The SCOPING OPINION:

Proposed Teesside Flexible Regas Port

Case Reference: EN040001

22 April 2024

Figure 8.1
Flood Zones and Rivers

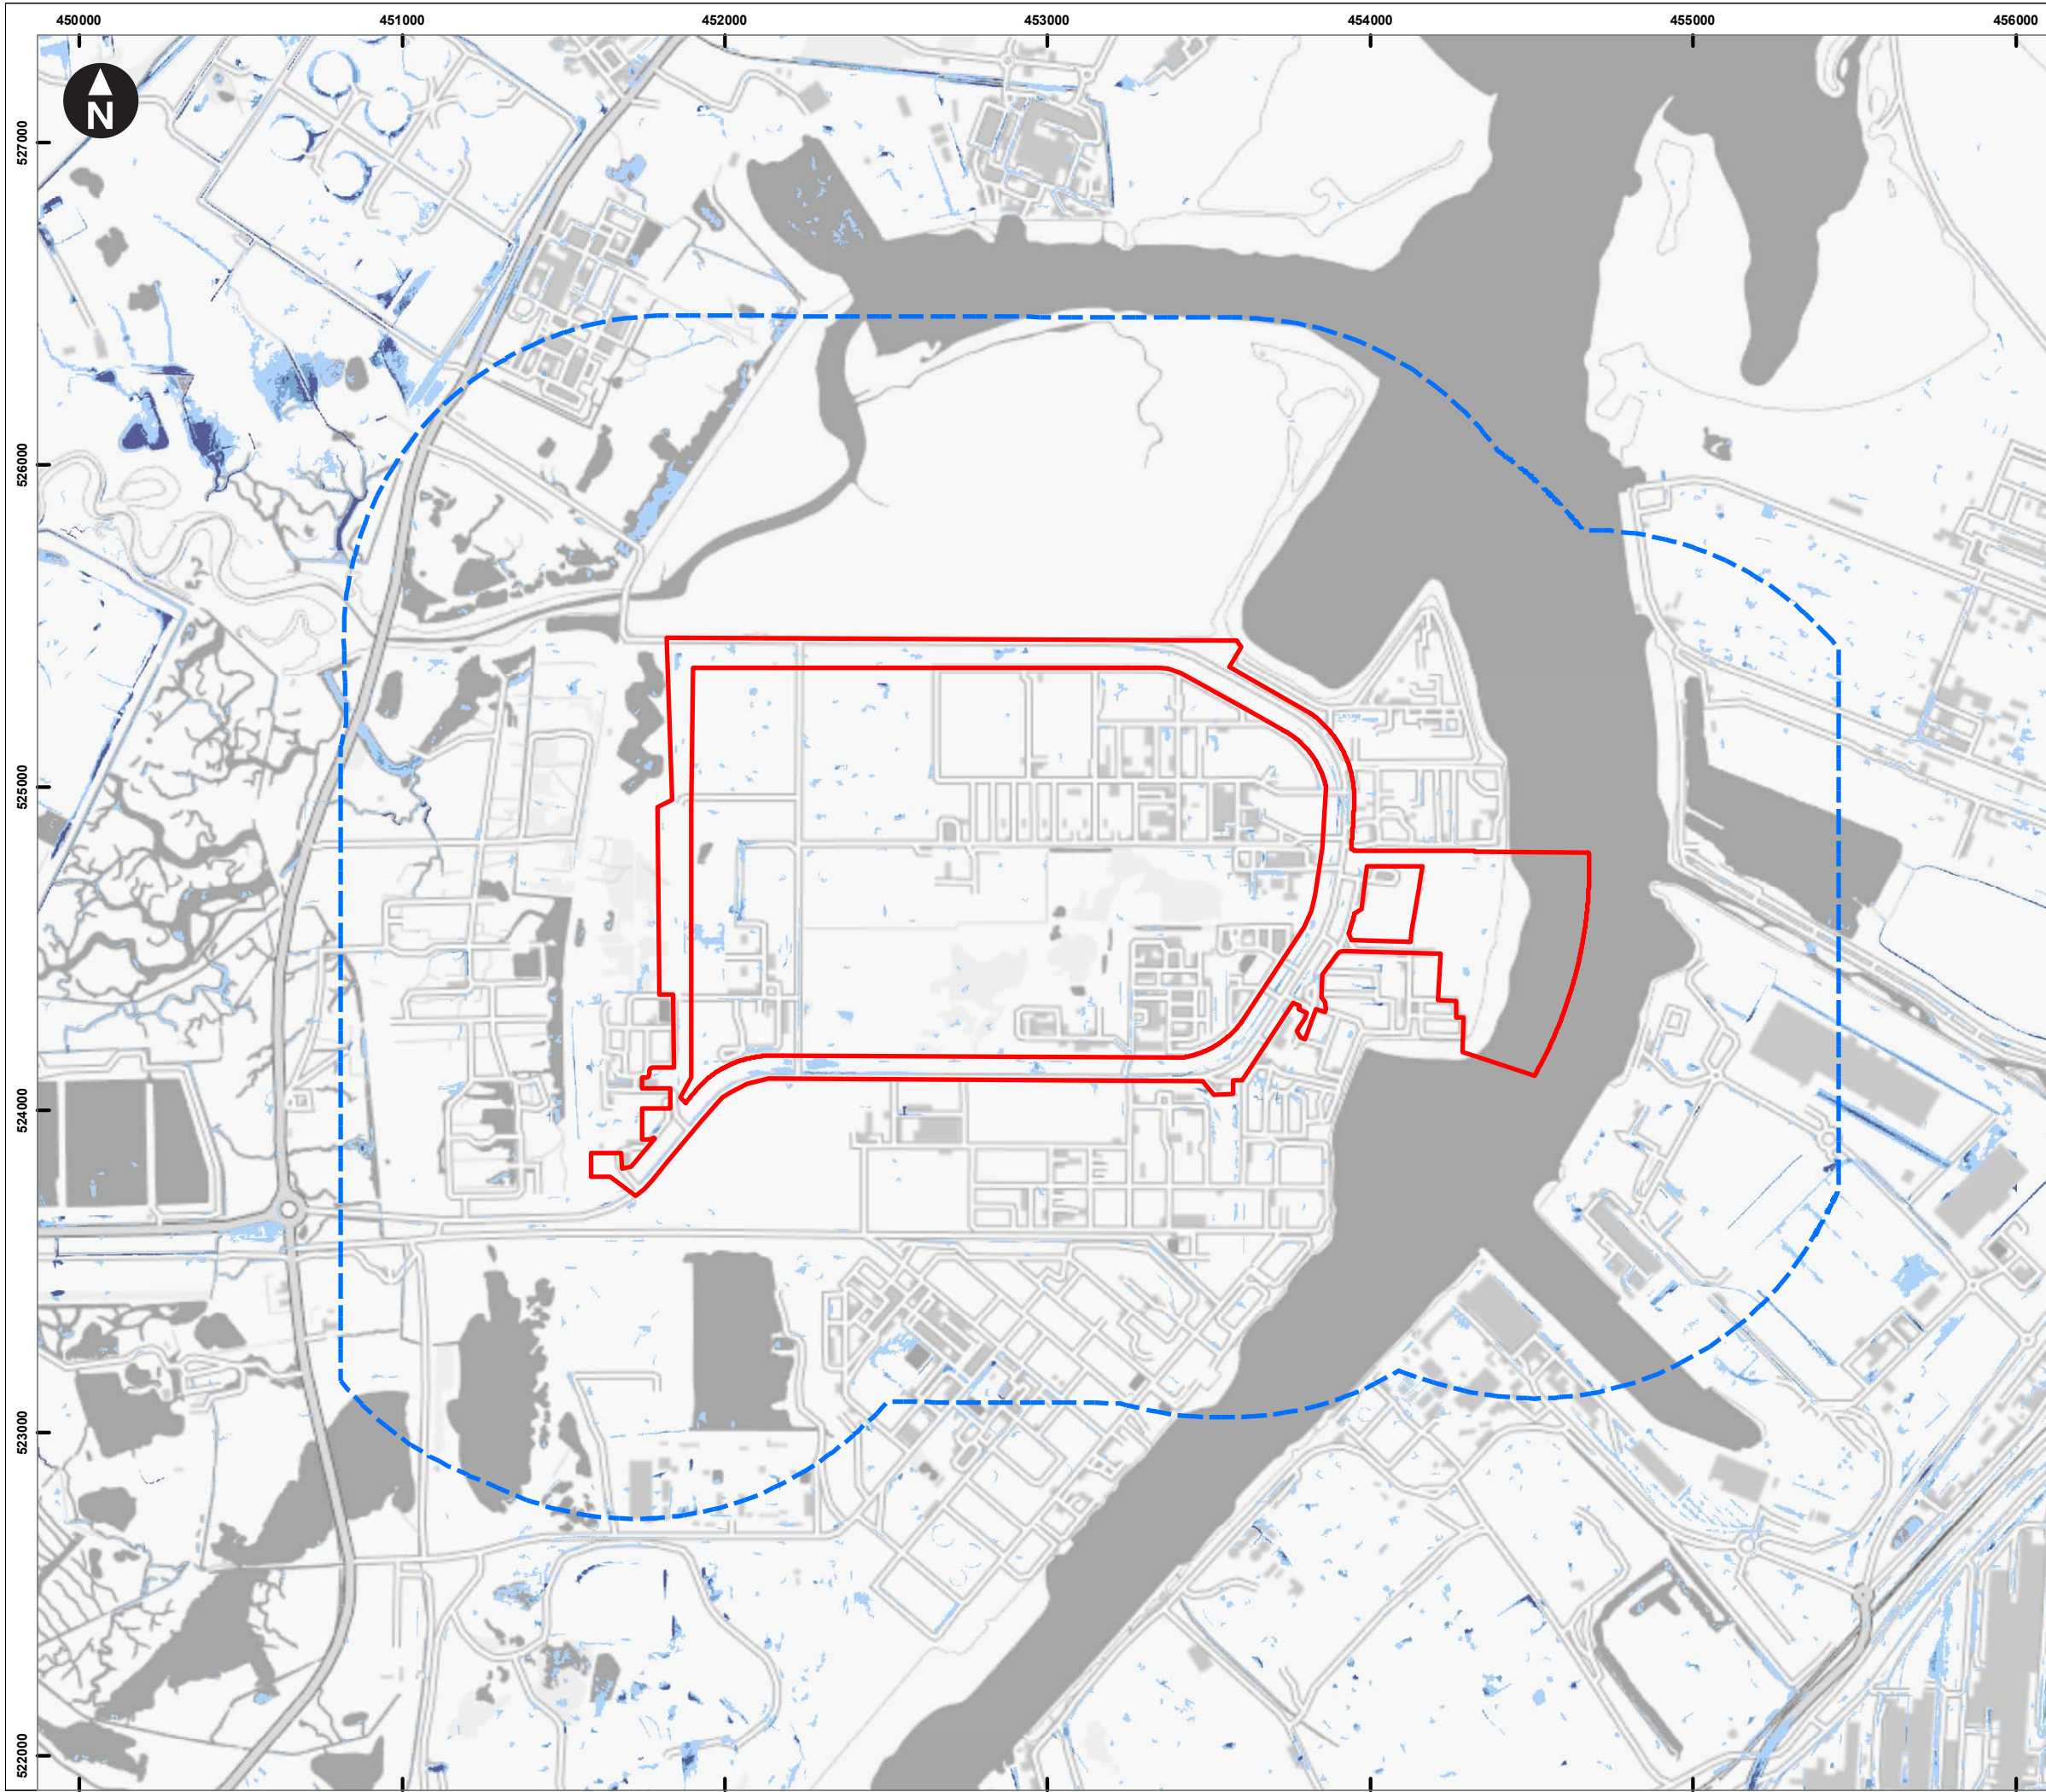
ID	Ref	Description	Inspectorate's comments
			differentiate between watercourse/ditch/pond as currently shown on Figure 8.6.
3.4.5	Paragraph 8.5.28 and Figure 8.1	Flood zones	The Scoping Report identifies Flood Zones across the Study Area however, it does not include sub-categories, such as an area of high probability (Flood Zone 3a) or functional floodplain (Flood Zone 3b). The ES should provide an accurate and consistent description of the baseline flood risk for each element of the Proposed Development and the description should clearly distinguish between Flood Zones, including Flood Zones 3a and 3b where relevant. The ES should include a figure to illustrate the extent of Flood Zones 3a and 3b.
